MIDTOWN COLLECTION AT HANNAH RIDGE FILING NO. 2

MIDTOWN COLLECTION AT
HANNAH RIDGE FILING NO. 2
JOB NO. 1116.30
JANUARY 15, 2019
SHEET 1 OF 3

NO.	REVISION	DATE
1	COUNTY COMMENTS	5-20-19
2	COUNTY COMMENTS	12-11-19

BY: \_\_\_\_\_ DEPUTY  
MIDTOWN COLLECTION AT  
HANNAH RIDGE FILING NO. 2  
JOB NO. 1116.30  
JANUARY 15, 2019  
SHEET 1 OF 3

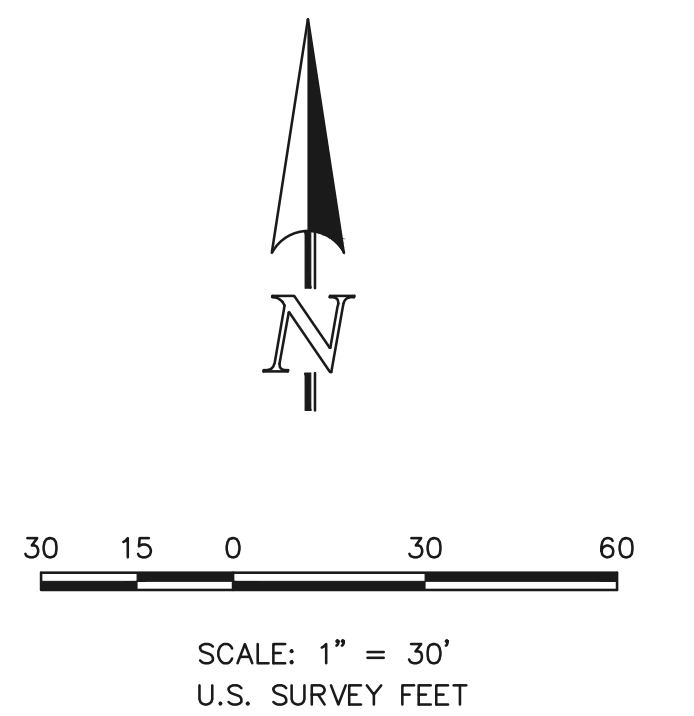
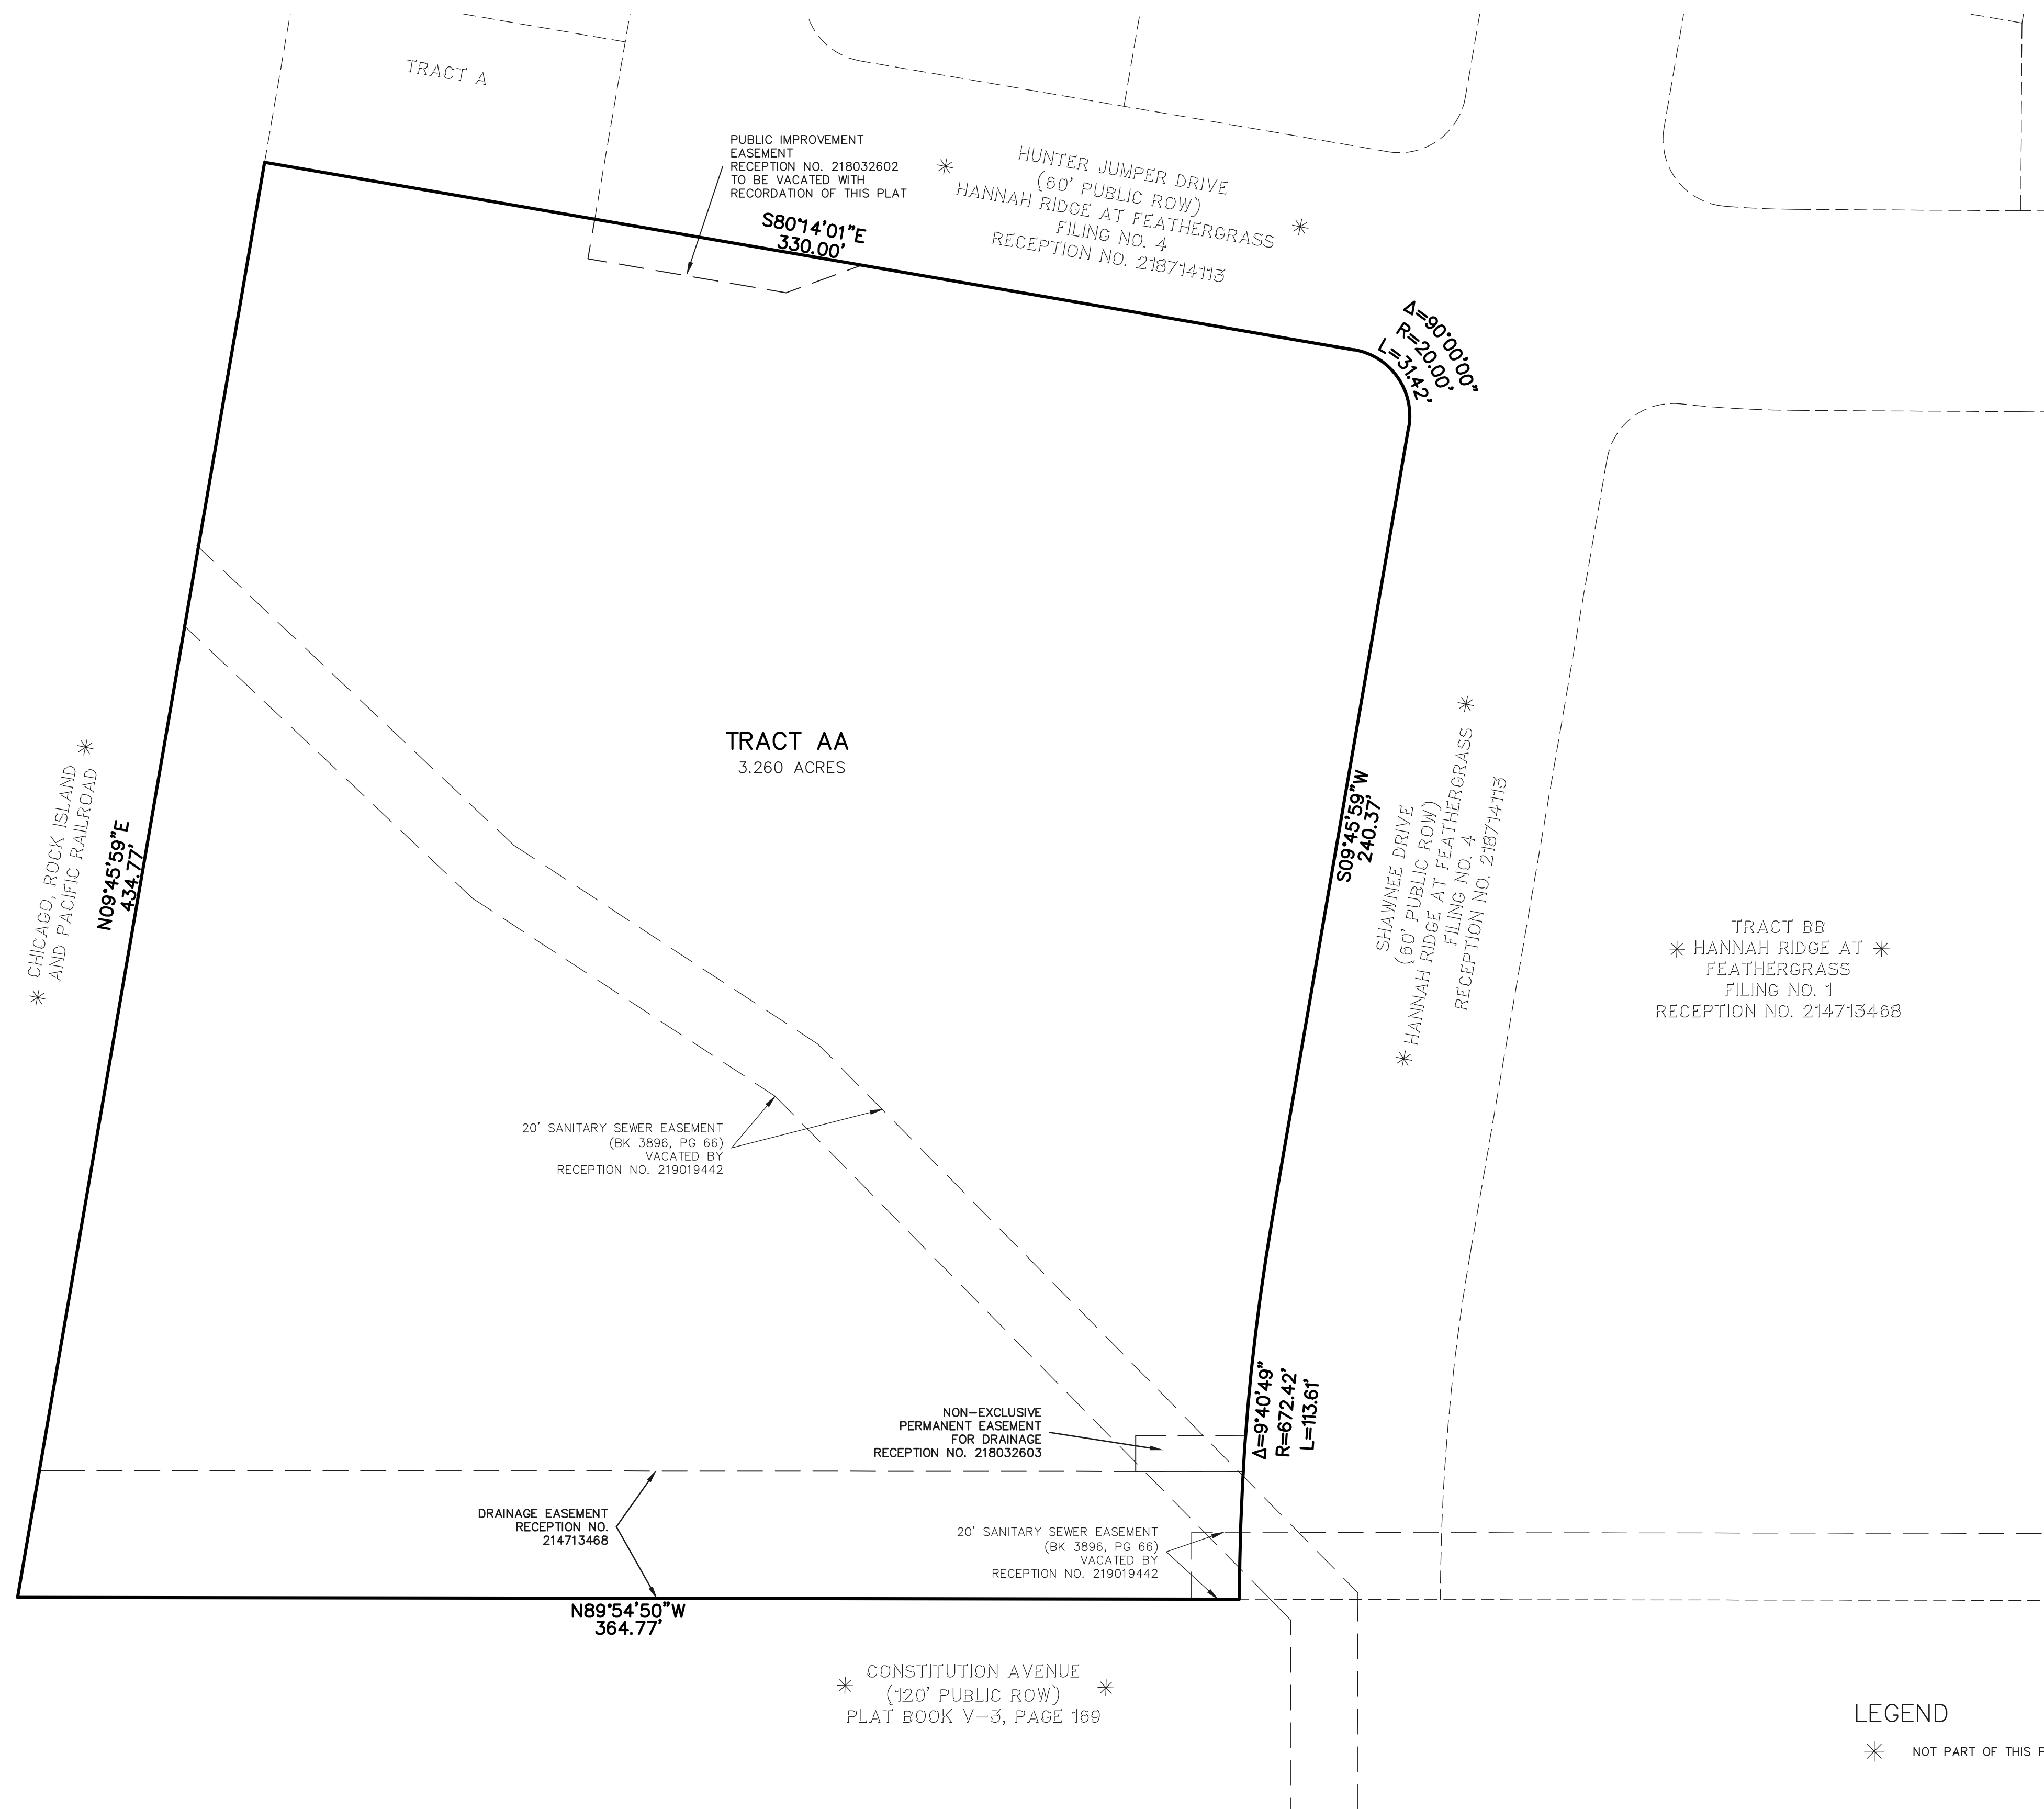
Add the noise wall note: who is installing it and who is maintaining it please.

LOI states that one filing is in a District and the other plat filing is in the other District. Cimmaron Hills has commented that the fil 2 plat is within their District. This fil 2 plat is NOT in Falcon

add note) "Due to the unique nature of this development, narrow and constrained easements, drainage easements and drainage pipes in those easements will be maintained by the Midtown Collection at Hannah Ridge Home Owners association. This is regardless of whether they contain storm water from the development or off-site public storm water. See Detention Pond Maintenance Agreement".

Detention Pond Maintenance Agreement recorded at reception number.... ETC note please add.
